No3 Woodside Lane,
Fixby,
Huddersfield
HD2 2HA

Application number 2023/92215 erection of residential development off Woodside Lane, Fixby

Drawing  
**UD-488-03**

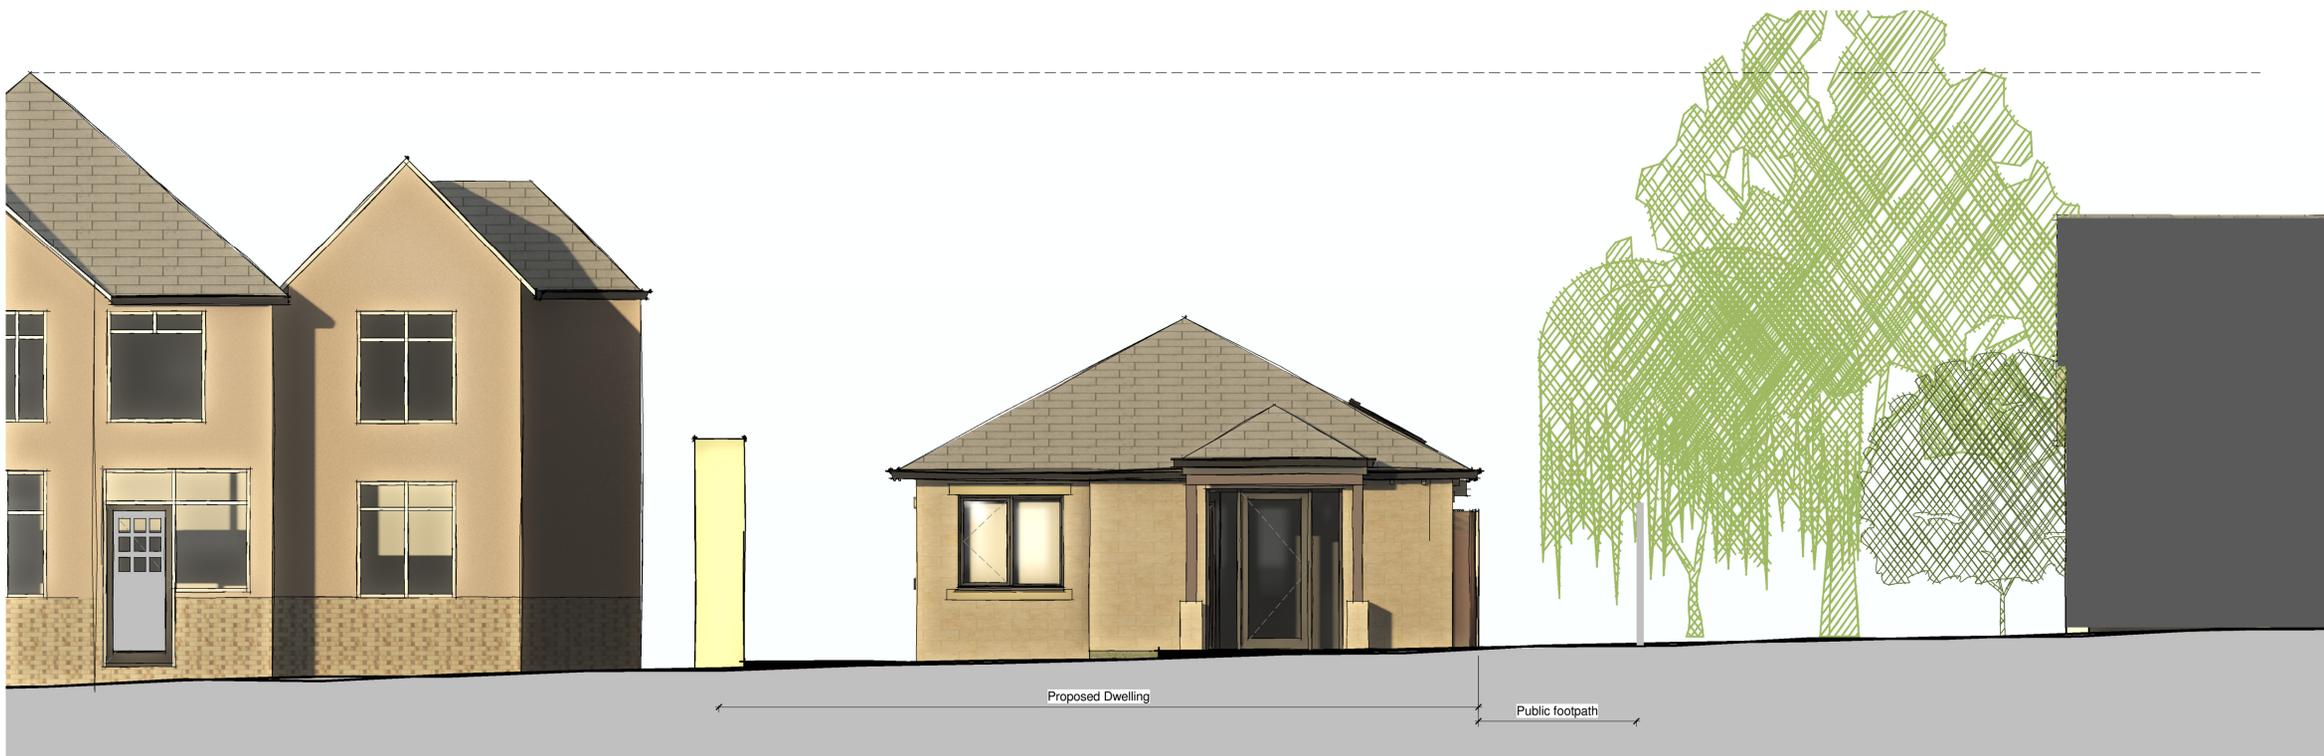
The overshadowing created by the proposed dwelling which would be directly opposite to our kitchen and main bedroom, would be extremely extensive, leaving little to no natural light because the proposed property would rest right against the boundary. Our kitchen dining table is set in the bay window and we would lose privacy to our bedroom which as stated above overlooks the plot in that area (see images 2a&2b). Both our kitchen and bedroom have large bay windows that are 1m from the face of the hedge, the portion of the hedge closest to the kitchen has been reduced in height to allow more natural light to come into the kitchen (please image 1a) and allow us to sit at our kitchen dining table and enjoy the many birds using the hedge as nesting and protection. I have attached photographs to demonstrate these points. The overshadowing effects would obviously have even more impact in the winter months. The design of the property appears to be more than single storey which exacerbates the overshadowing along with the fact that ground level of the **proposed plot is 650mm above that of ours.**

The drawings submitted do not in our opinion represent the real picture; they are merely pretty pictures which show little constructional detail and sizes and seek to minimise the obvious issue of the narrowness of the plot. They are not an accurate reflection of how dimensionally impractical unsuitable and detrimental the construction would be. For instance, our beech hedge (see images 1a,2a,2b) which runs the full length of the proposed plot would not in our opinion survive any construction, as excavation for foundations and site clearance the site would without doubt cut and damage roots. The hedge which ranges in height from 2.8m to 3 m x1.8 m wide is a massive part of the property's charm and security and is irreplaceable. I again would urge you to look at the attached photos or preferably visit site. Our concern that is that this valuable asset would be killed or irreparably damaged, leaving us in an invidious legal position and be a huge loss of habitat for wildlife and privacy and security of our property.

We absolutely concur with this statement feel nothing has changed in that regard and that granting this permission would have a very unfair and unnecessary impact on the area and would have a detrimental effect on our property and lives in relation to the overshadowing . The proposed dwelling gives no consideration whatsoever to either the impact on their immediate neighbours or indeed the rest of the Lane. This plot is simply not wide enough to take a dwelling and regardless what the drawings seek to suggest both boundaries across the width of the plot would be compromised.

Drawing UD-488-01 Revision:

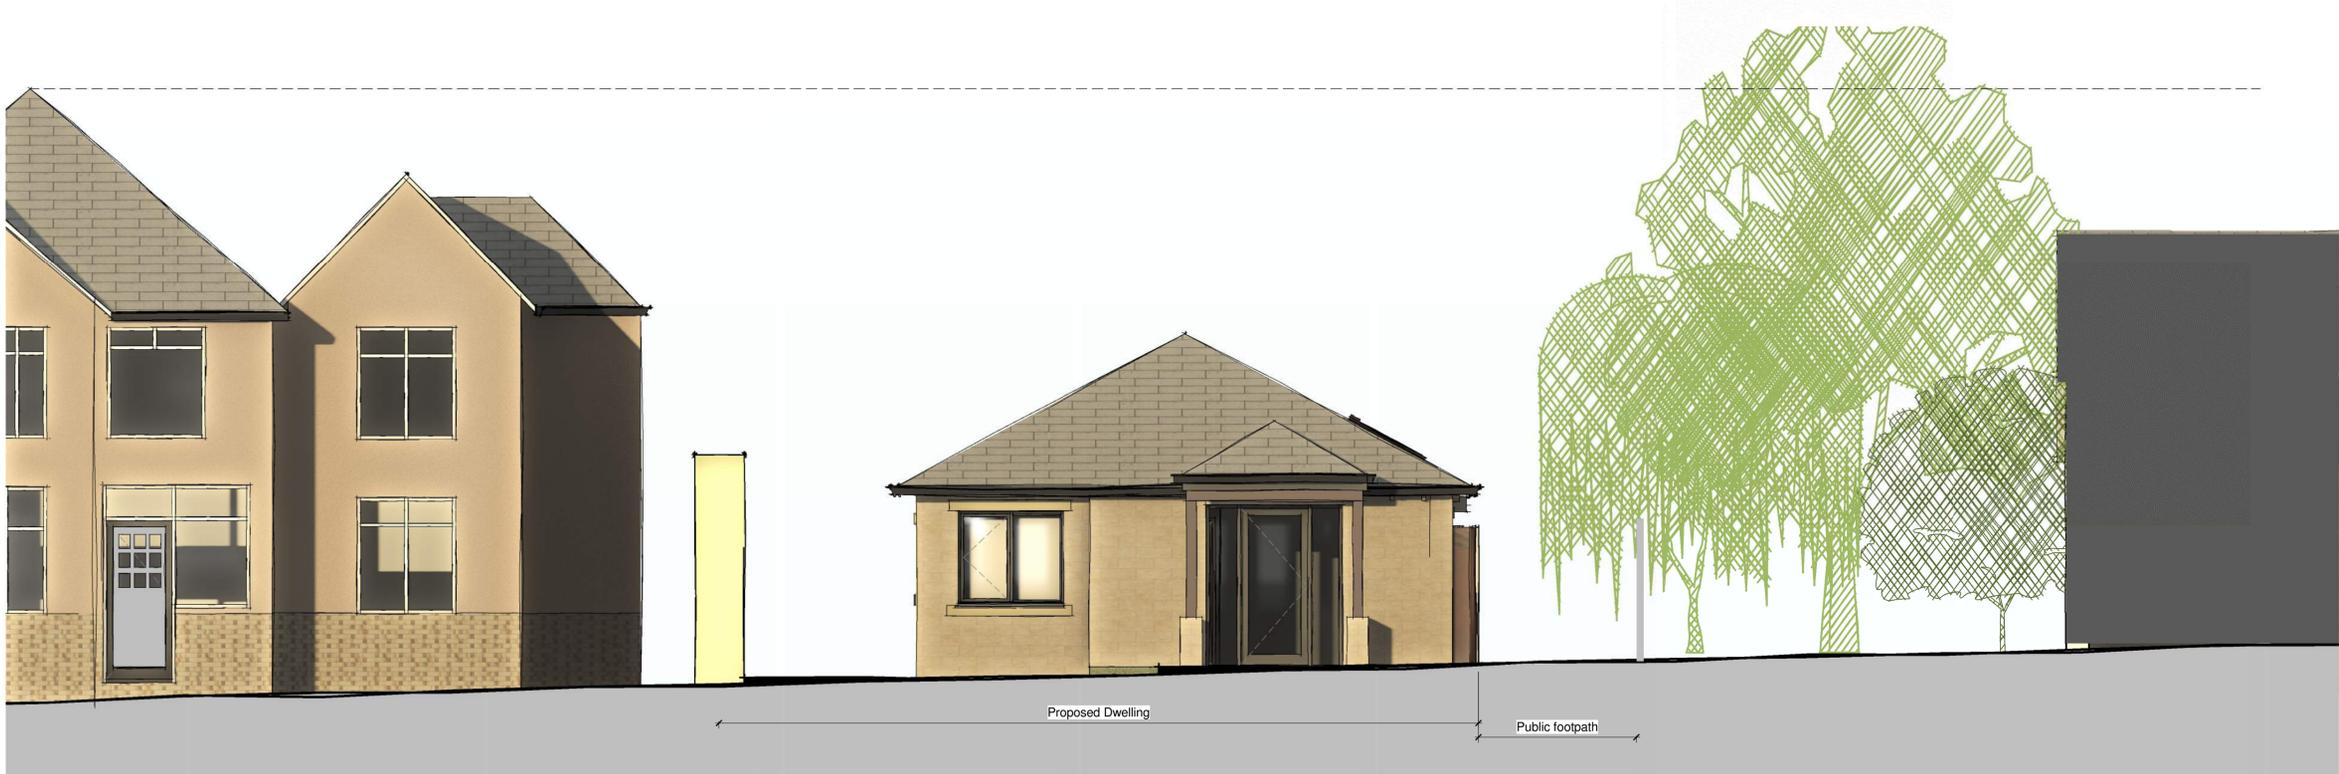
The positioning of the proposed dwelling according to the drawings online would be sited directly adjacent to our house itself.

between our property and our nearest neighbour, No 1 is 9m. It is our opinion the distance to the proposed dwelling would be as little as 2m which is not at all representative or in keeping with any of the other properties in the whole of the lane or indeed the whole immediate area, and unlike the other houses in the lane will produce an overcrowded look and have a negative aspect and not within the character of the area. This is probably why this plot wasn't used previously, during the original construction of Woodside lane there was no number 5 Woodside lane due to the limited size of the plot. The lack of space goes against the Kirklees Local Development Plan LP24 11.10 and also the NPPF section 12 item 130 – a) and c)

Contrary to 3.18 of the Kirklees Highway Design Guide, and 10.82 (LP21) of the Local Development Plan, in our opinion there is not enough room for vehicles to safely turn in or out of the proposed site and the size of the plot is not adequate to allow turning within the grounds.
